Date: 09 March 2021
Our ref: 344382
Your ref: 3/2020/0667

**Planning consultation: Change of use and conversion of former fish hatchery to three holiday let units and creation of associated car park for six vehicles.
Location: Whitcher Well Fish Hatchery Whitendale Road Dunsop Bridge BB7 3BL**

SUMMARY OF NATURAL ENGLAND'S ADVICE

LANDSCAPE MASTERPLAN

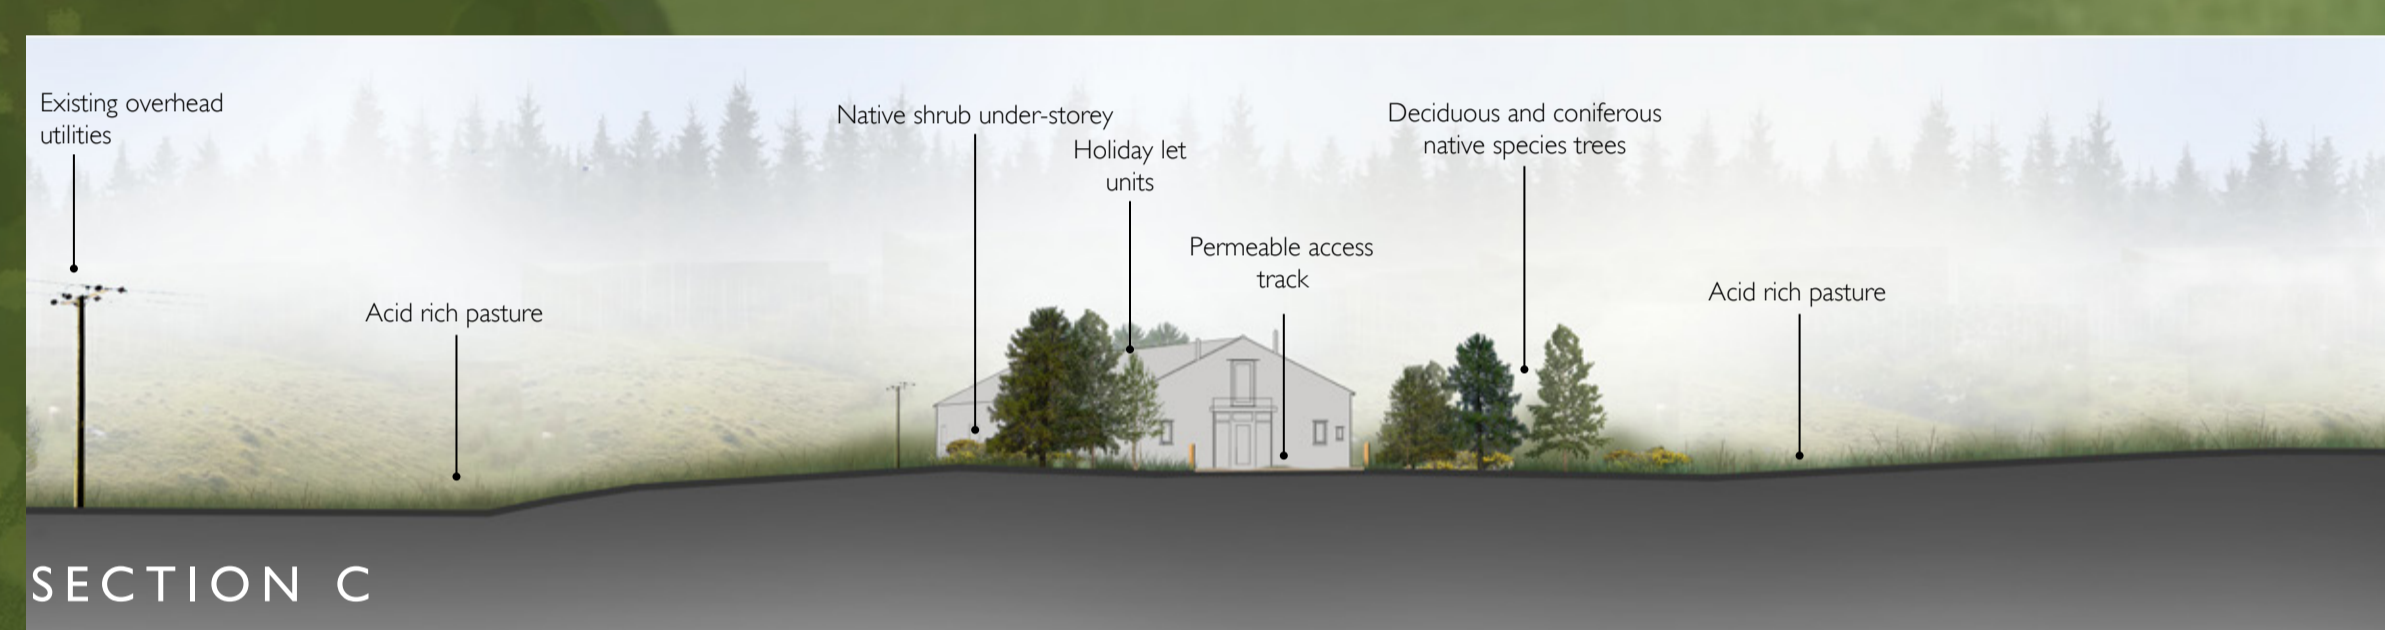
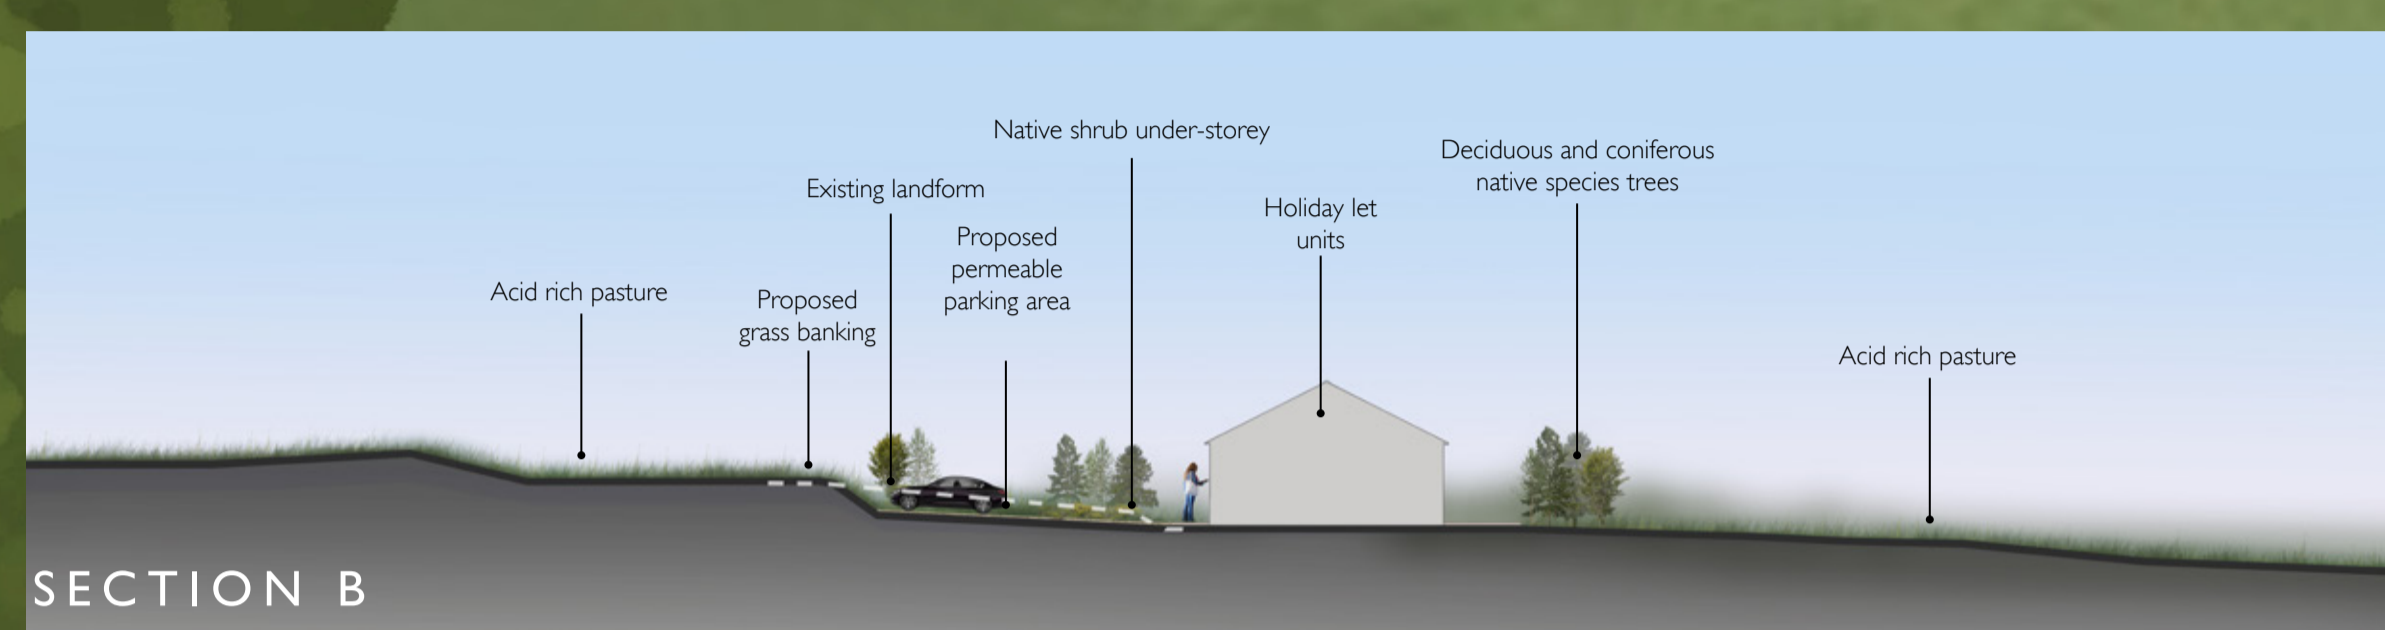
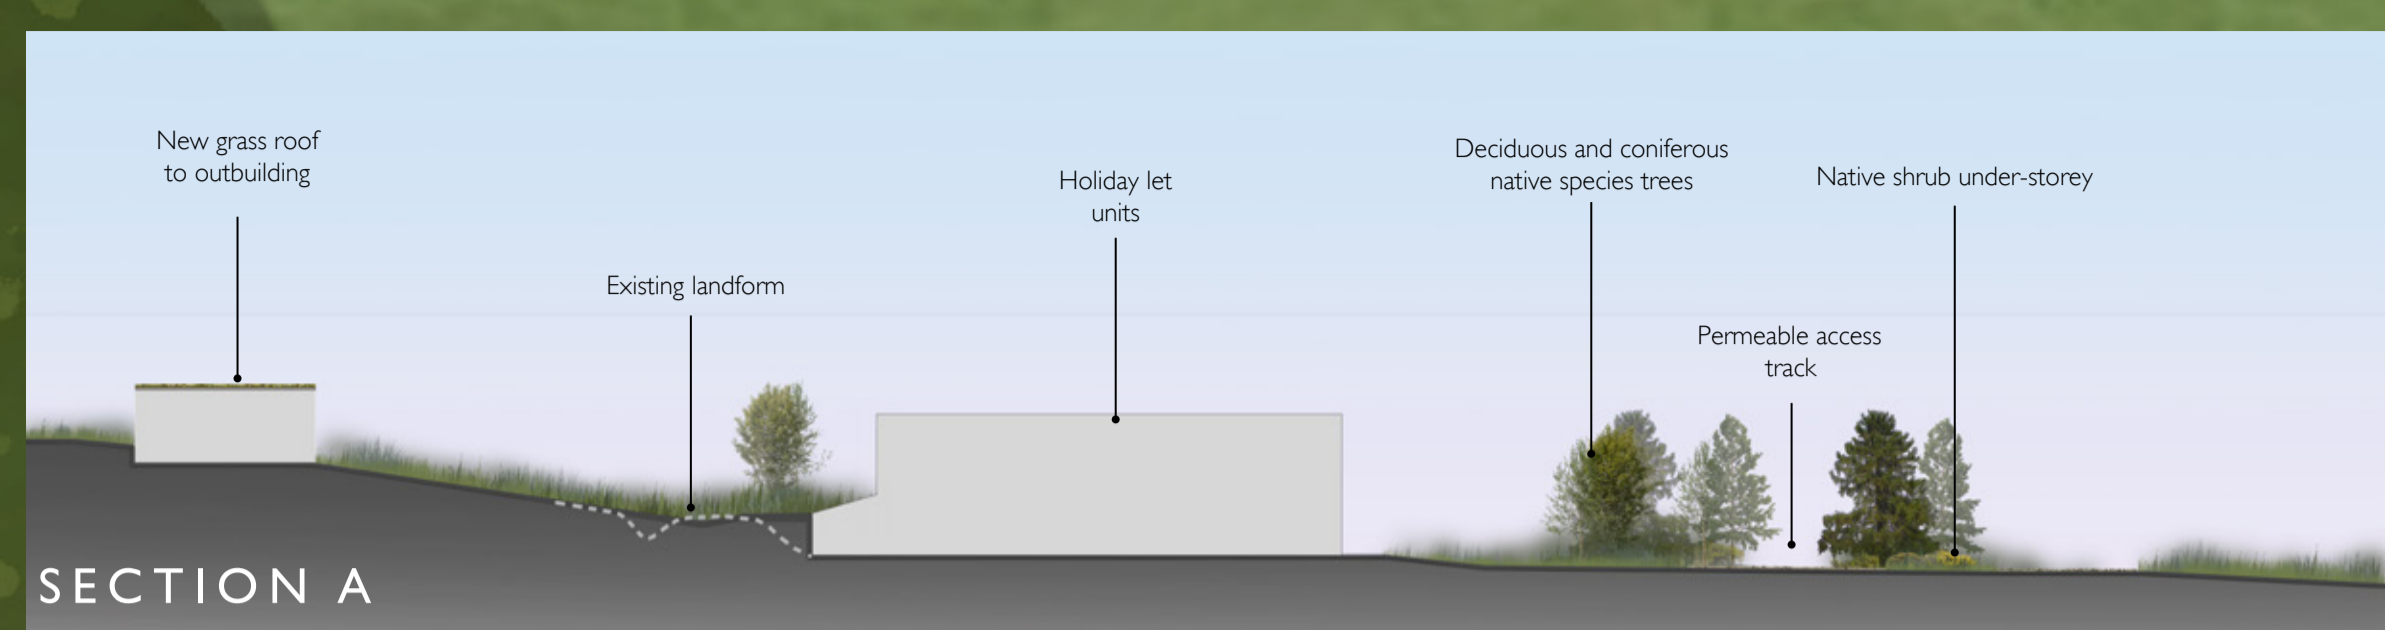
We have reviewed the amended Summary Landscape and Visual Impact Assessment (LVIA) (Rural Solutions, May 2019, Rev A), the Landscape Masterplan and Elevations and Typical Section as Proposed (5891 c/b/02 Rev B). We are satisfied that the proposed amendments to the elevations of the building, screening and lighting arrangements overcome our previous concerns we are confident that you now have the information you need to reach a fully informed decision.
